21 May 2012

**North West Rail Link (SSI-5100)**  
**Submission on behalf of Inala – Cnr Franklin Road and Castle Hill Road, Cherrybrook**

Further to our recent meeting on 19<sup>th</sup> April 2012 with Cecilia Densham and other representatives and following a review of the Environmental Impact Statement on exhibition (Environmental Impact Statement Stage 1-Major Civil Construction Works) we provide a number of comments for the Department's consideration.

Figure 14.3 Land use and community facilities – Cherrybrook station site

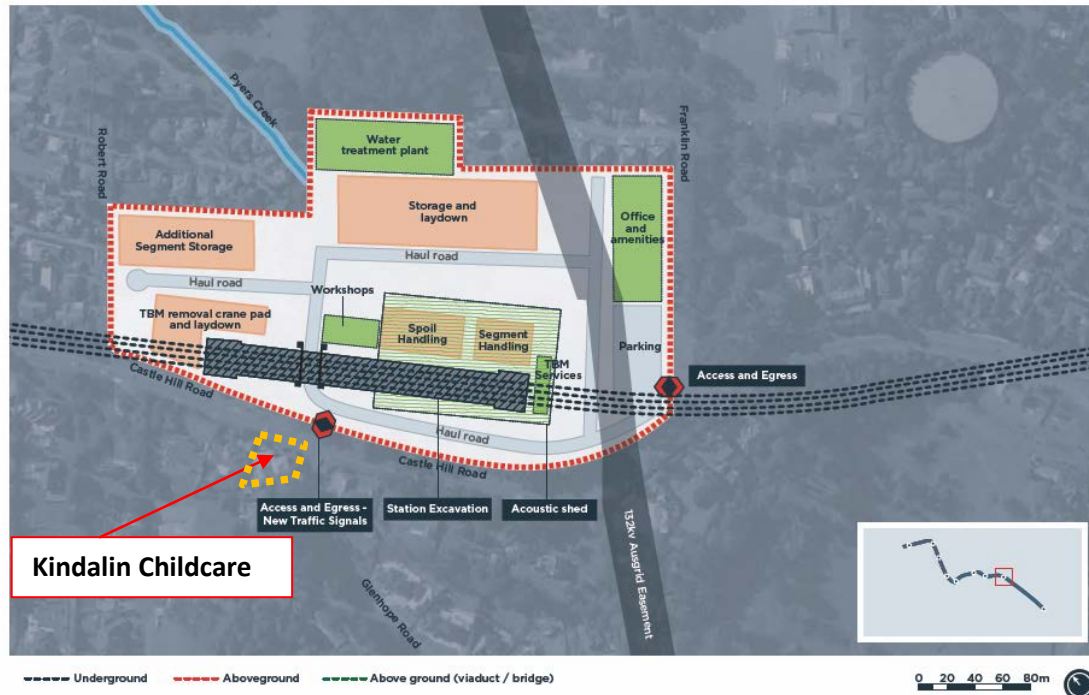
The Environmental Impact Statement Stage 1 - Major Civil Construction Works (the **EIS**) for the Northwest Rail Link (currently on exhibition) identifies a proposed station (Site 4 - Cherrybrook Station) in close proximity to both of Inala's sites. As this has the potential to cause conflicts with both of the existing Inala services, we have provided a number of comments in regard to the operation of the service, outlined a number of concerns, and proposed management measures for consideration by the Department of Planning and Infrastructure.

The noise and traffic impacts are associated with construction works at Cherrybrook Station. Inala is located directly opposite the construction site for Cherrybrook Station (on the corner of Franklin Road and Castle Hill Road). The construction works involve spoil removal activities and associated truck movements over a 24 hour operation/ 7 days per week and an access and egress point (traffic lights) immediately adjacent the Inala site. The majority of truck movements are anticipated between the hours of 7am to 6pm and involve truck-and-dog or semi-trailer tippers able to carry 12.5m<sup>3</sup>. The technical paper (*Construction Traffic and Transport Management – Table 2.5*) estimates overall tunnelling heavy vehicle movements for the station at 29,600 trucks or 275 per day (one way) – total 550 truck movements per day.

The EIS nominates the Inala site (Receiver Area D - 80metres from the works) as a sensitive receiver with predicted noise levels exceeding the required levels during the daytime period for the period [NML (Noise Management Levels) exceedances less than 10dB predicted] for the Station Box Construction phase of the works (EIS – Chapter 10 Noise and Vibration – Construction - *Table 10.11 Predicted noise level exceedances at Cherrybrook Station*).

We request the EIS (Chapter 10 Noise and Vibration - Construction) and associated tables be updated to include the impact of construction noise on the Inala site over a 24 hour period (evening and night periods) (*Table 10.10 Nearest sensitive receivers to Cherrybrook Station* and *Table 10.11 Predicted noise level exceedances at Cherrybrook Station*). The site contains permanent intellectually disabled residents and is occupied 24 hours a day over 7 days.

- a) No truck entry or exit on Franklin Road. All truck movements should be via the entry from Castle Hill Road (Glenhope Road).
- b) Construction of an uninterrupted perimeter hoarding fence on Franklin up to Castle Hill Road from Kayla Way at an effective height that will prove an effective acoustic barrier and visual screening of the proposed construction (Site 4 – Cherrybrook Station) from clients as they go about their daily activities. Further discussion will be required with management of Inala in designing an appropriate solution.

- l) The EIS (Chapter 10 Noise and Vibration - Construction) and associated tables be updated to include the impact of construction noise on the Inala site over a 24 hour period.
